**Re: NOVA Entrance (Formerly Schott Solar)
5201 Hawking Dr. SE
Traffic Circulation Layout
Engineer's/Architect's Stamp dated 3-5-15 (Q16-DA5000)**

Re: Schott Solar Phase 1 Traffic Circulation Layout Certification

Re: Schott Solar Phase 1 Grading and Drainage Plan

Re: Schott Solar Phase 1 Grading and Drainage Plan Comments

JOB NO. 366450	REV. NO.
FILENAME	DWG. NO. GN-CD-103
SCALE 1"=30'

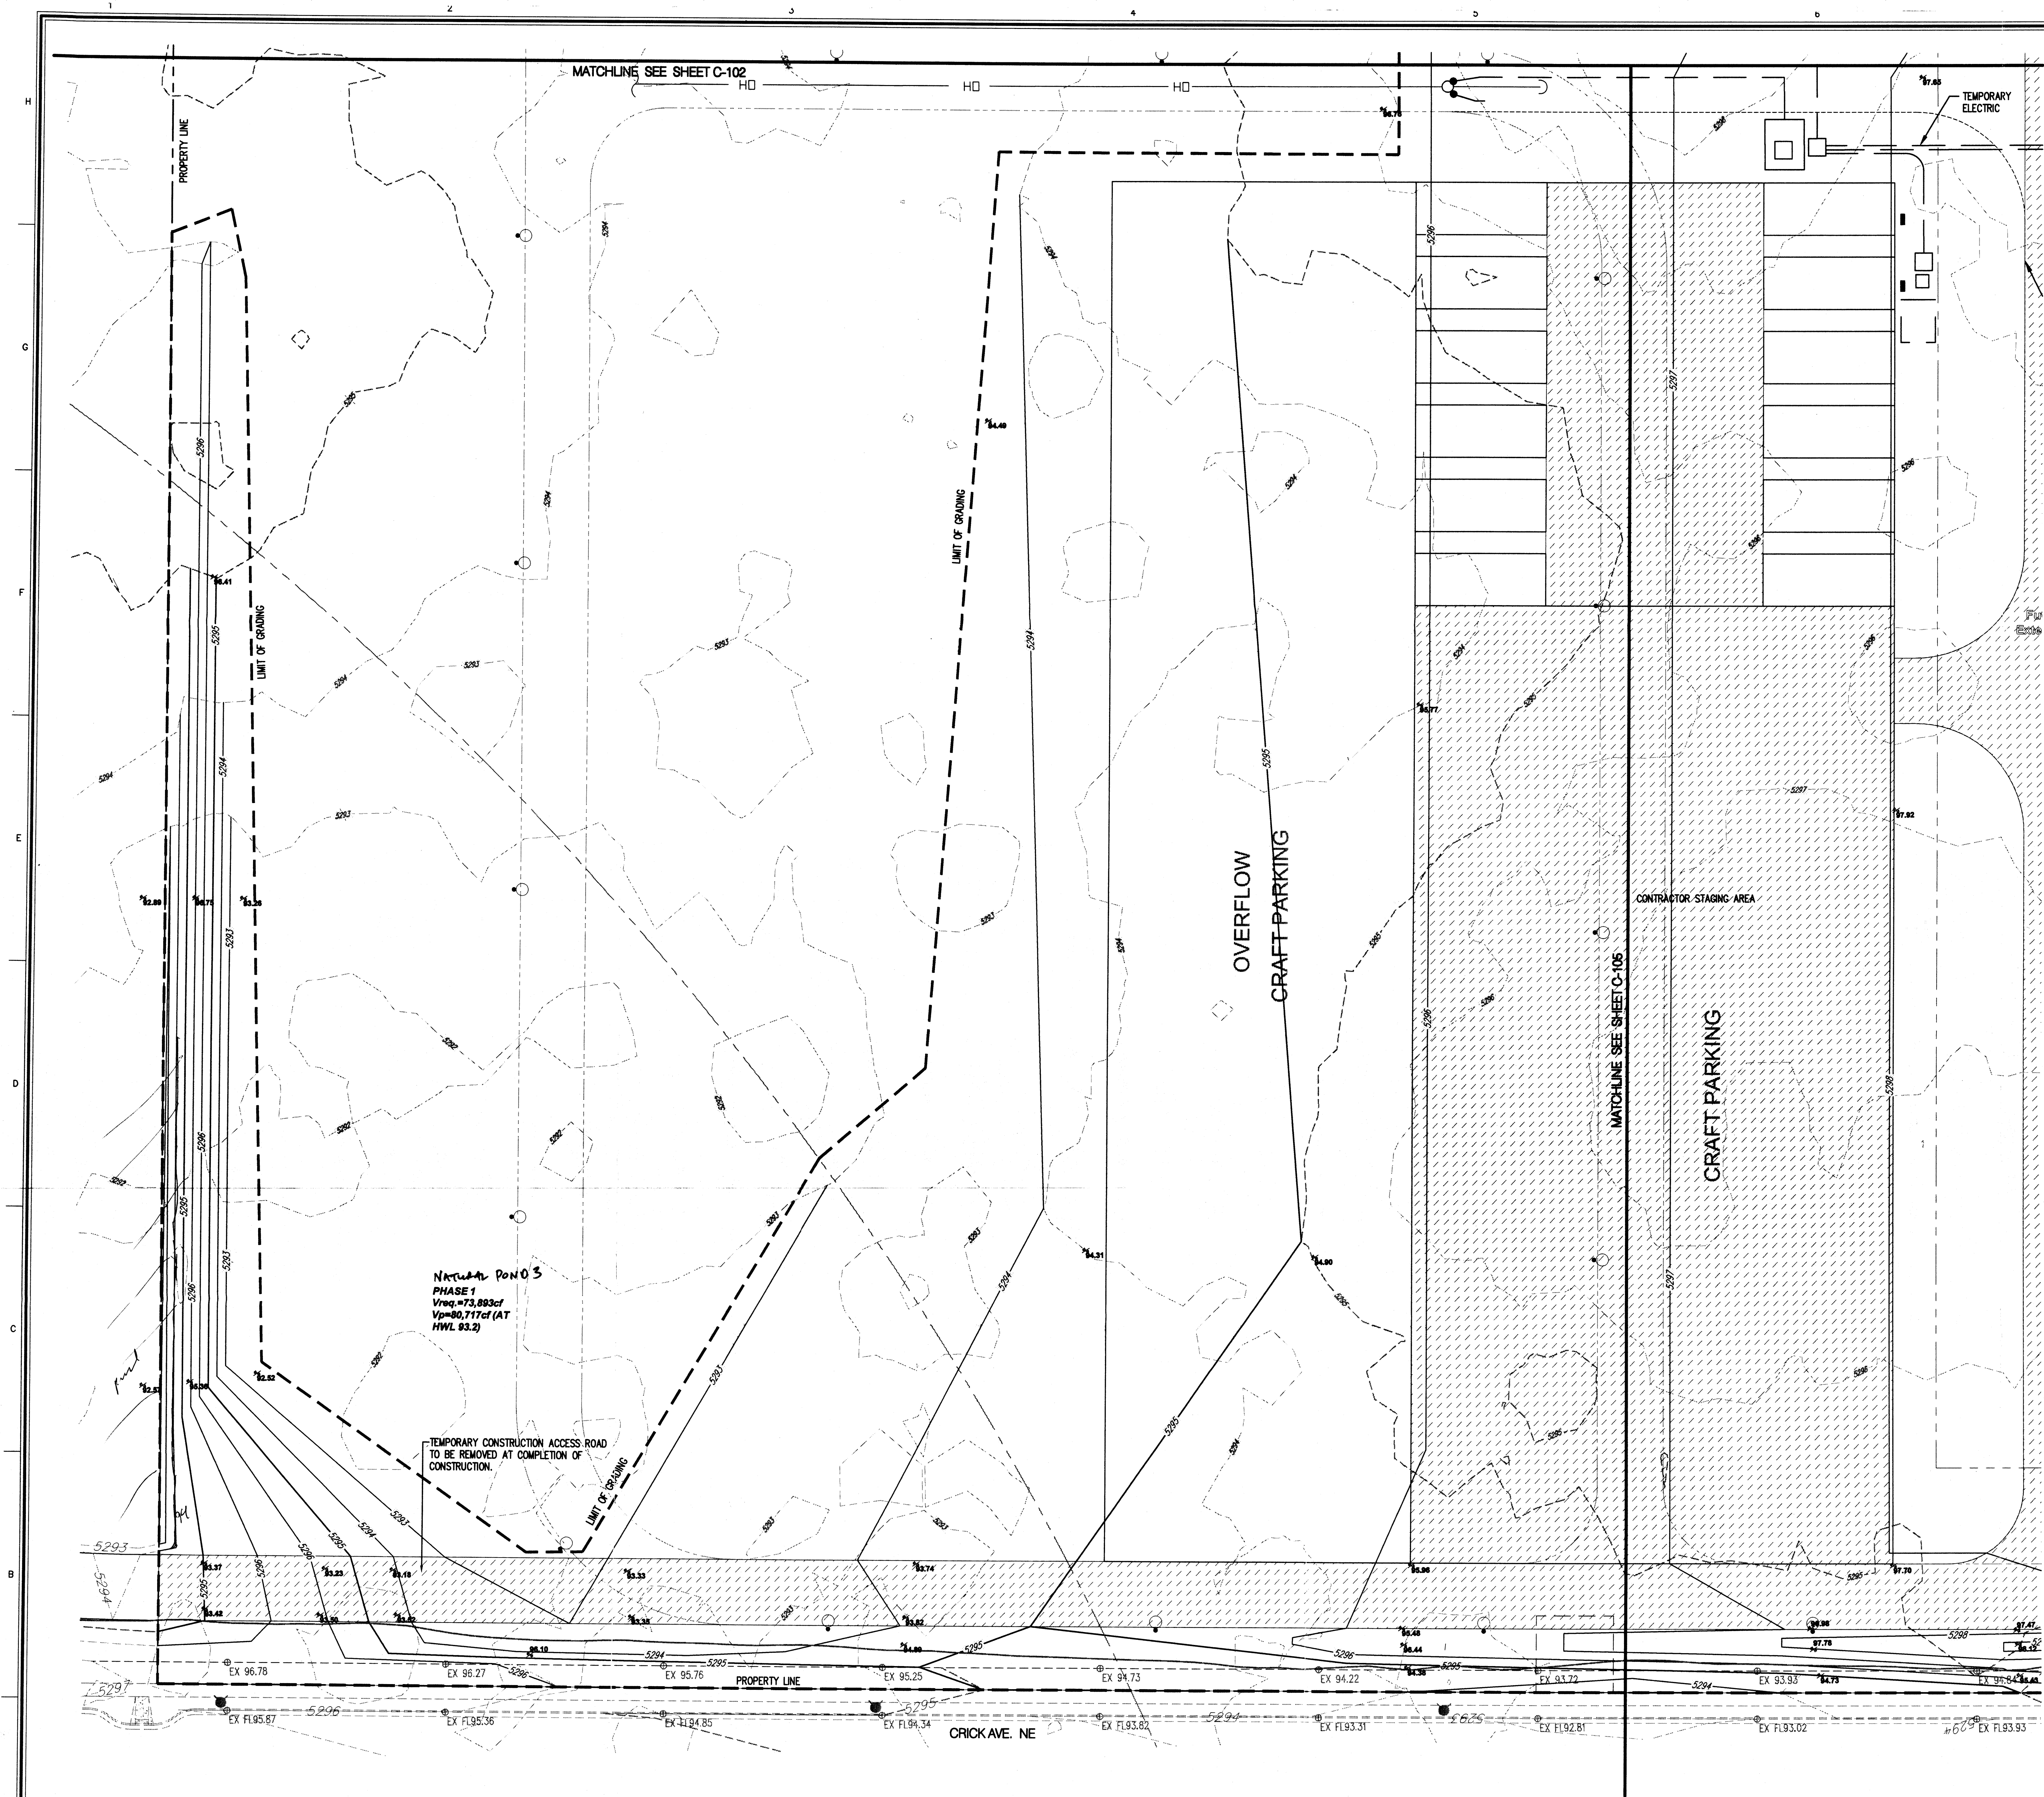
103:
Part of Basin 7 is in Basin 5 (more of a DMP comment).

A couple of build notes in the northwest area are cut-off. The entire note should fit on one sheet.

One grate elevation is at 95.63 and surrounding grades are 98/99. Seems a little low.

Note 9. The curb cut detail is not on the sheet.
